Project Name:	Deering Place Playspace	Project ID:	2014-095
Address:	500 Cumberland Avenue	CBL:	047 B002001
Applicant:	Kevin Dean of Opportunity Alliance		
Planner:	Shukria Wiar

On July 3, 2014, the Planning Authority approved with conditions a Level I Site Alteration site plan for improvements to an existing enclosed play area at the Opportunity Alliance Cumberland Avenue facility at 500 Cumberland Avenue. The decision is based upon the application, documents and plans as submitted and prepared by Regina Leonard and Tom Fowler and dated 05.20.2014. The proposal was reviewed for conformance with the standards of Portland's site plan ordinance.

3' Ø PRECAST CATCH BASIN
NOT TO SCALE

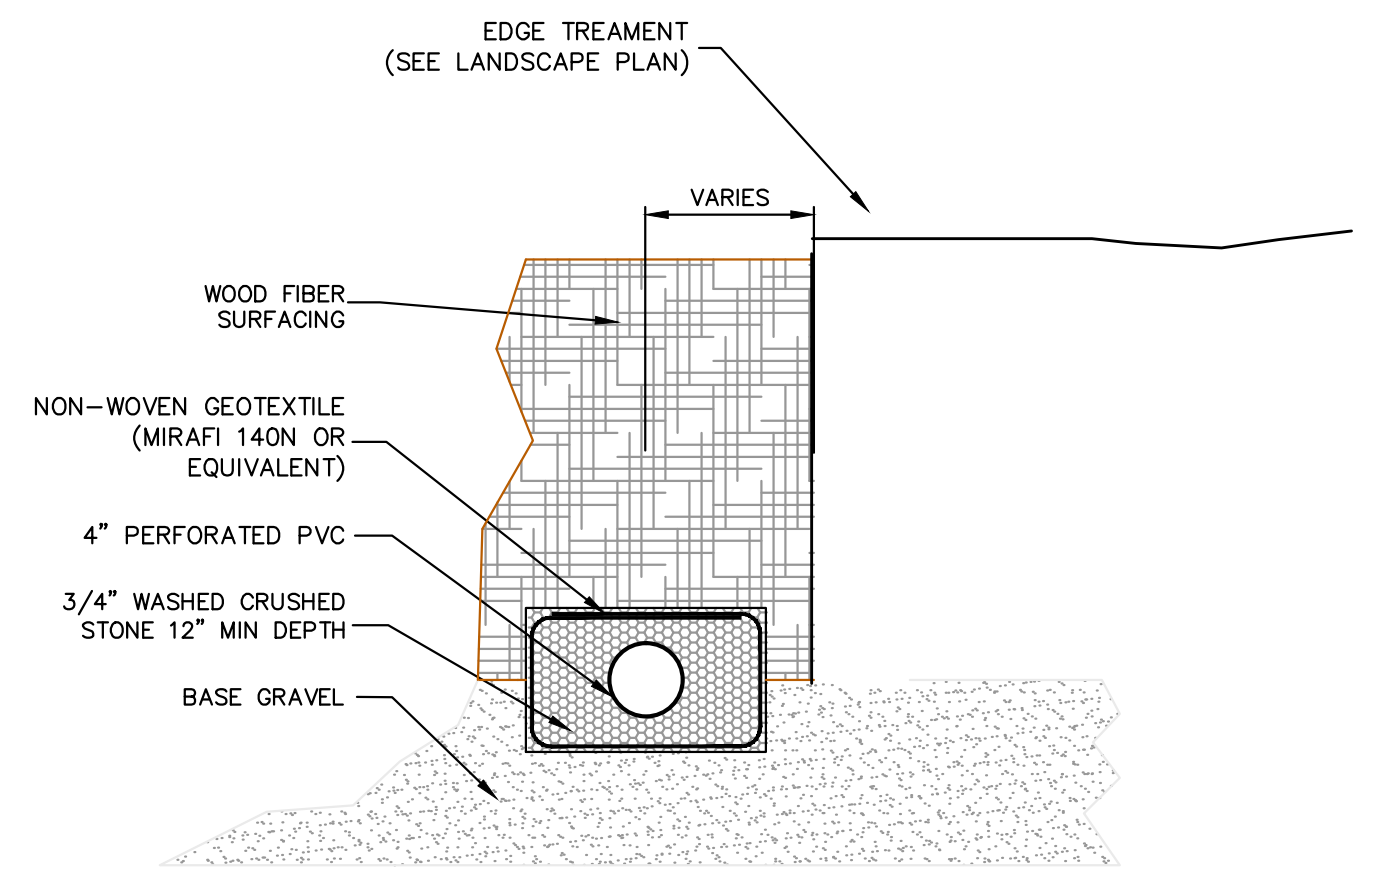
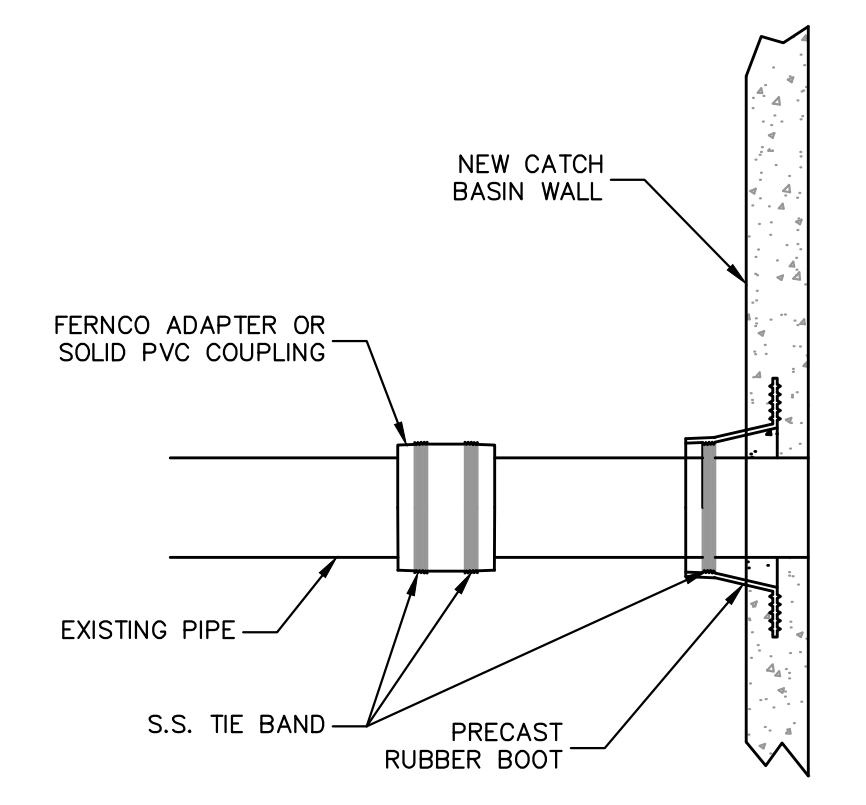
1. The plans shall show or note catch basin inlet protection (silt sack) to be installed at the on-site, down-gradient catch basin.
